From: Travis Lythall
Sent: Monday, 7 December 2020 5:42 PM
To: 'Prity Cleary'
Cc: 'Suzie Hendry'; 'Gayatri Sawe'; 'Vicki van Dijk'
Subject: RE: SSD 9472 - Sikh Grammar School - Request for Additional information
Attachments: RFI Request for Additional Information_04122020_035605_.pdf; PT18022r02 - Proposed Sikh Grammar School Rouse Hill CTMP_Final_V3a.pdf; PT18022DA01 Model (1).pdf

In relation to the attached RFI, please see below comprising formal comments provided by Positive Traffic. As a general note, Positive Traffic confirm that locations of trucks and vehicle movements by stages would be subject to a separate Construction Traffic Management Plan (CTMP). A Preliminary CTMP was previously prepared (and submitted); however, detailed information cannot be provided until the Detailed Design phase prior to the issue of the relevant Construction Certificate. Notwithstanding, the comments are noted as follows:

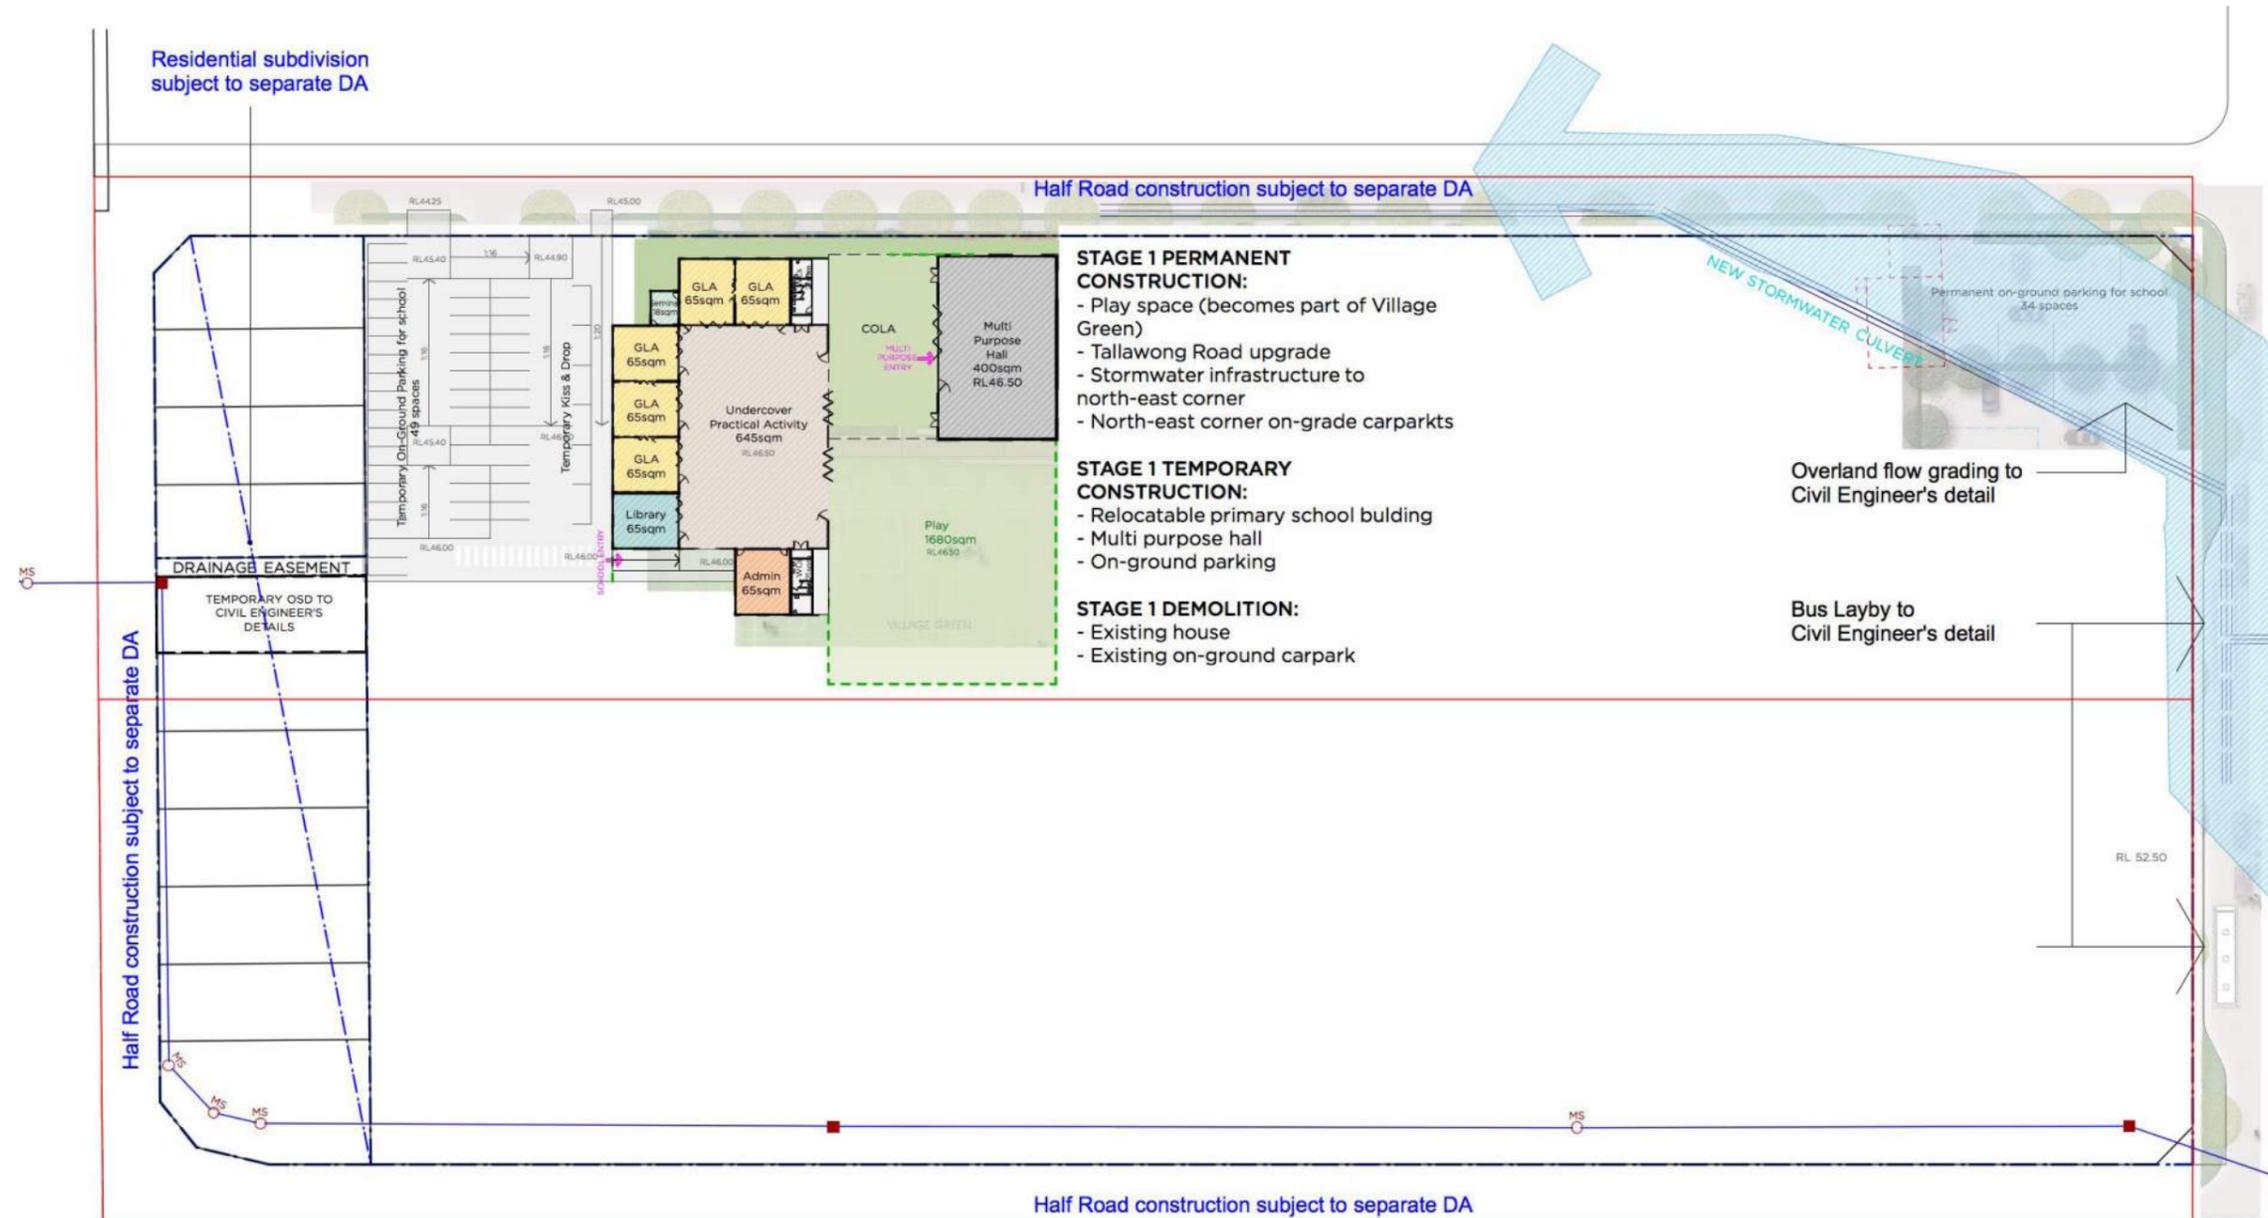
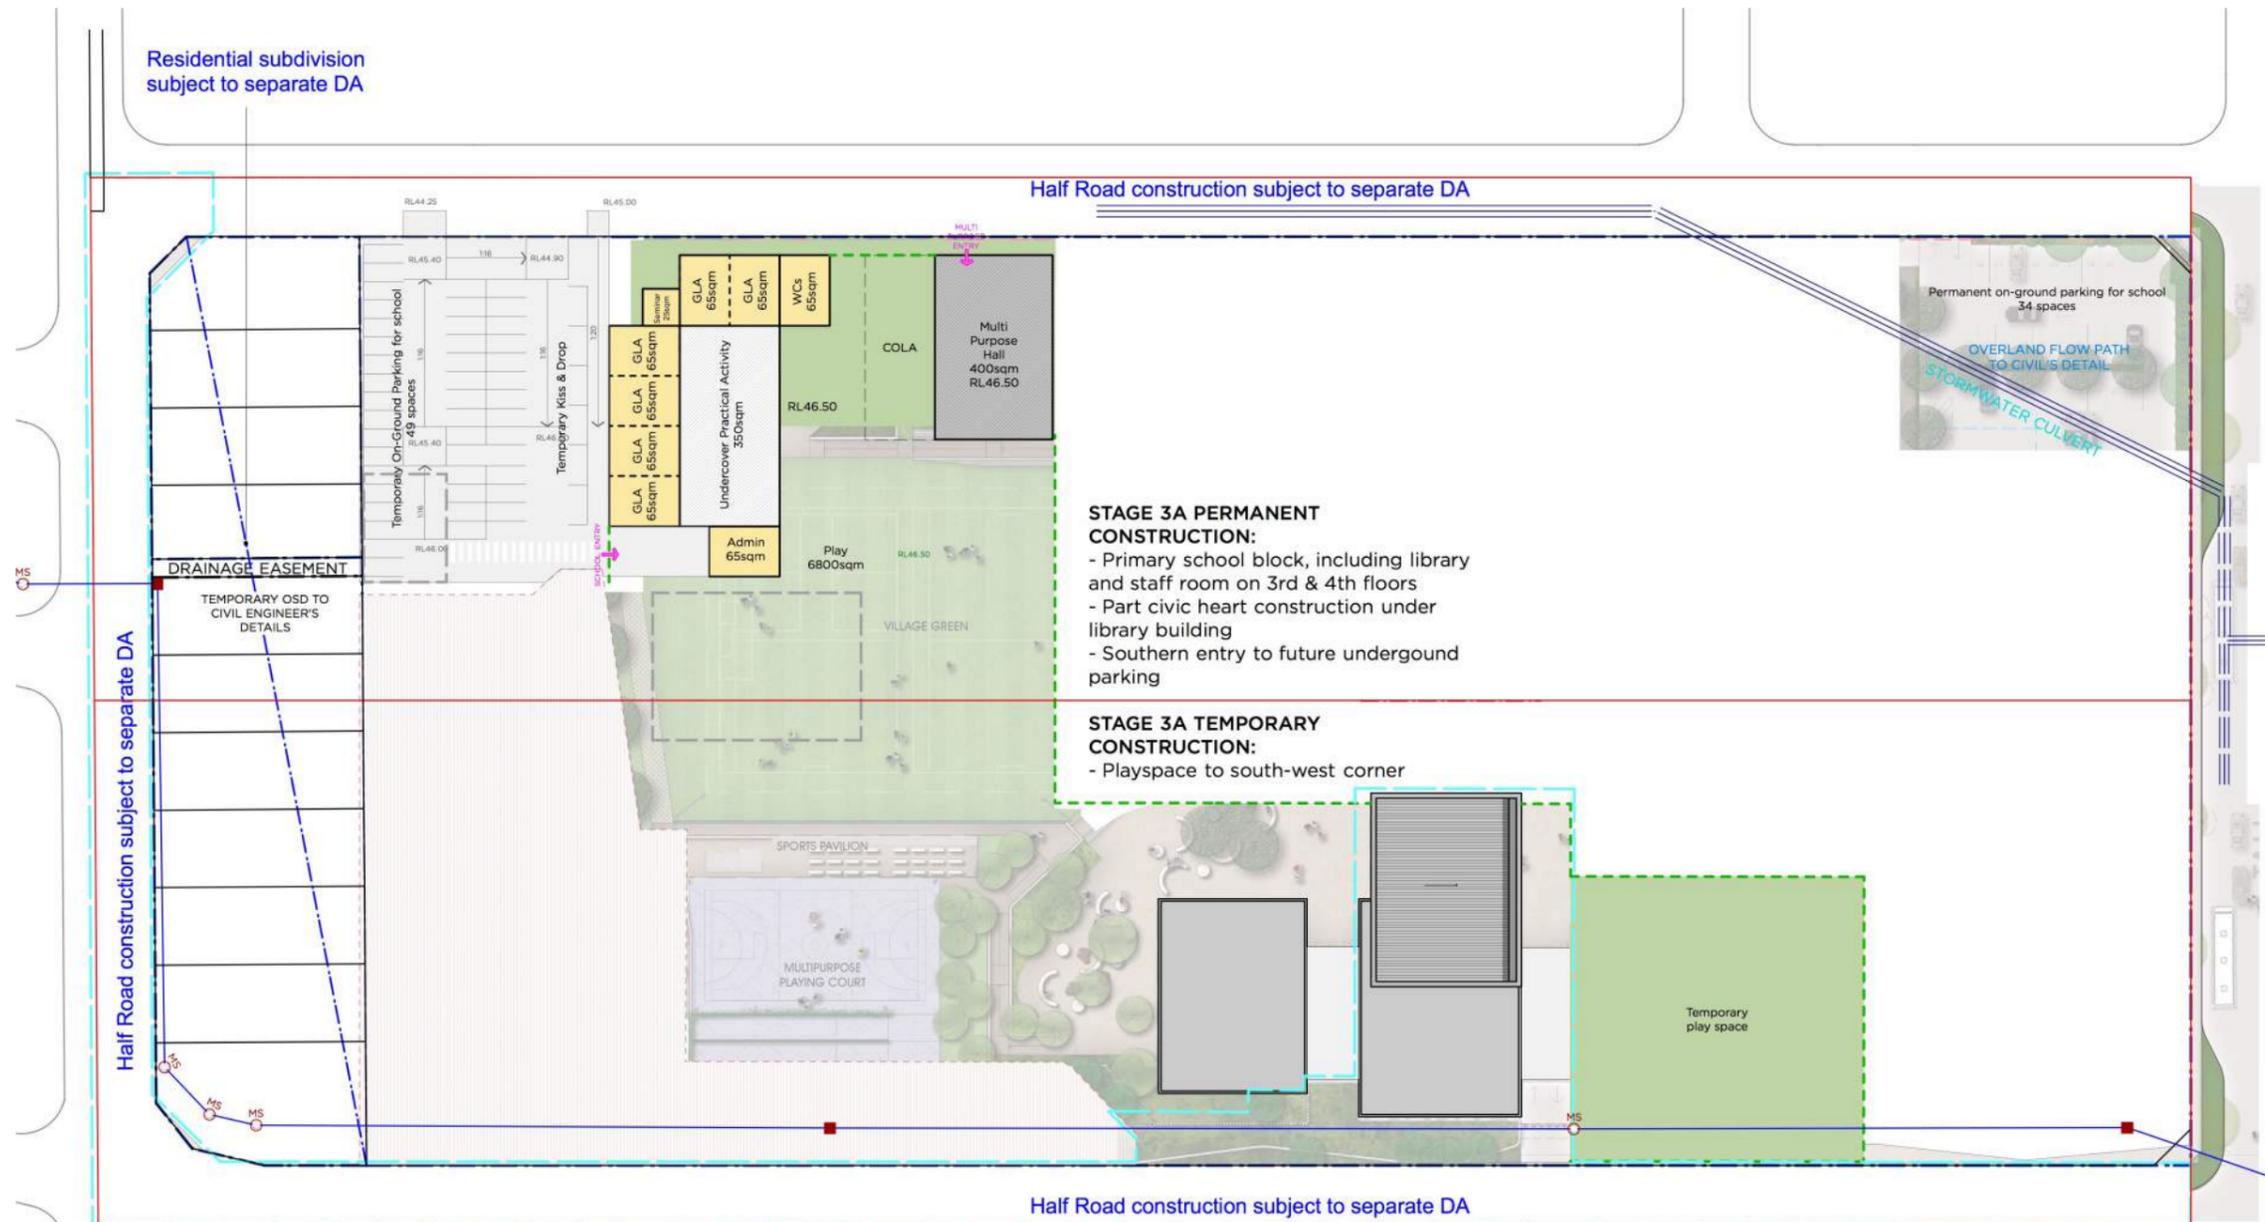
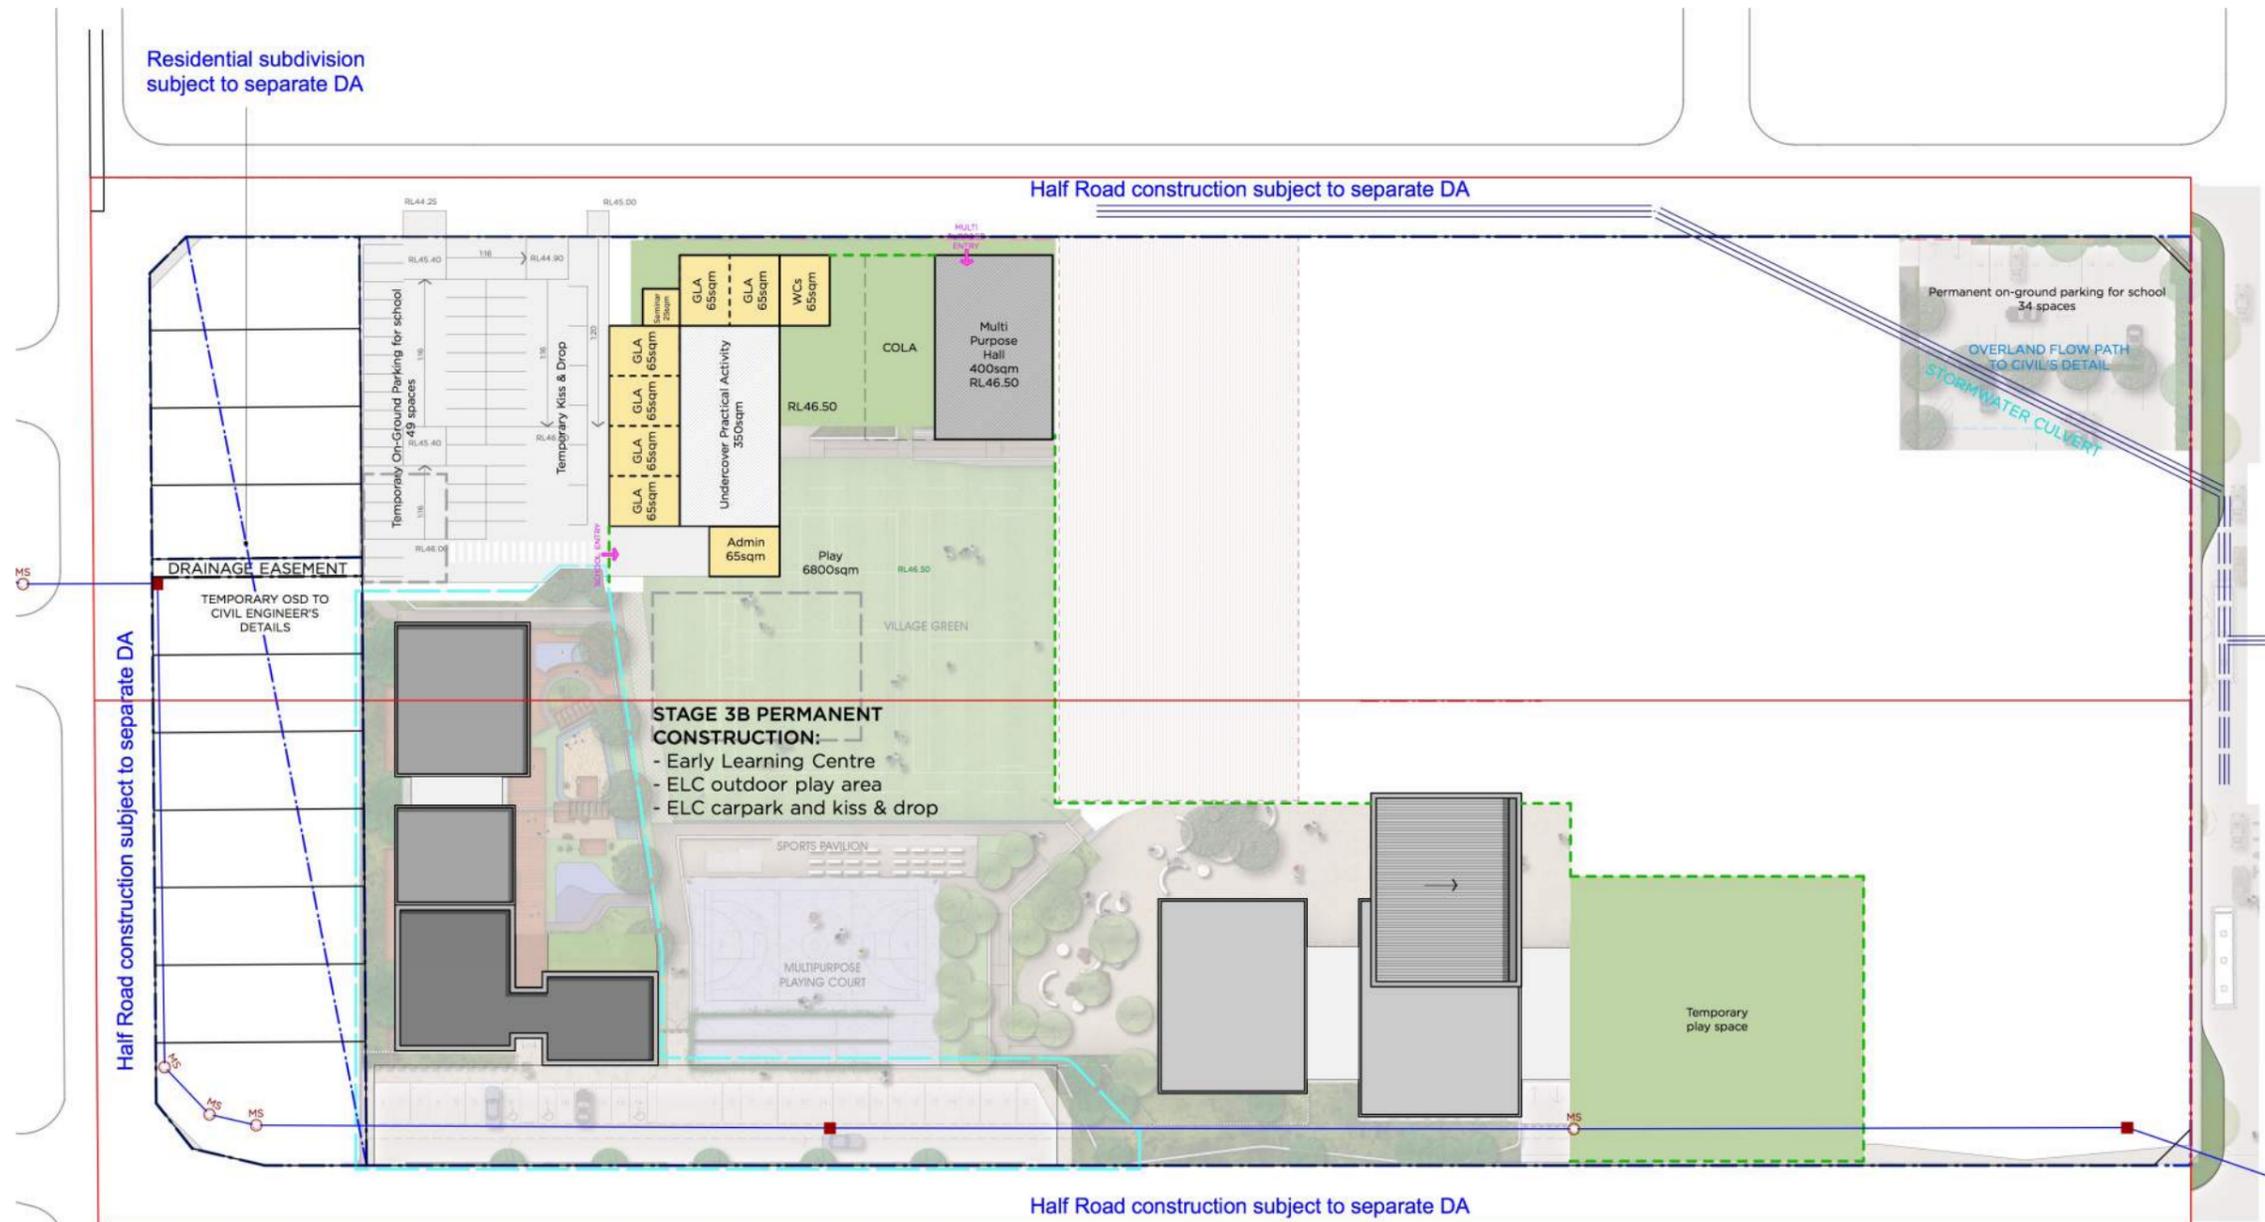
It is noted that throughout all the submitted documents (EIS report, RTS report and supplementary RTS) the construction timeframe is stated as 10 years. However, the staging plans in the Architectural Design Report

(pages 59- 69 in Appendix 4 of the RTS) reflects 24-year timeframe. These staging plans are to be revised to reflect a 10-year construction timeframe so it's consistent with the submitted documents.

It is noted, that the EIS reported on a 10-year construction program as a result of the staged construction; however, it is confirmed that the ultimate built form of the Site would not be realised until a 24-year timeframe. The staging plans are to remain as submitted.
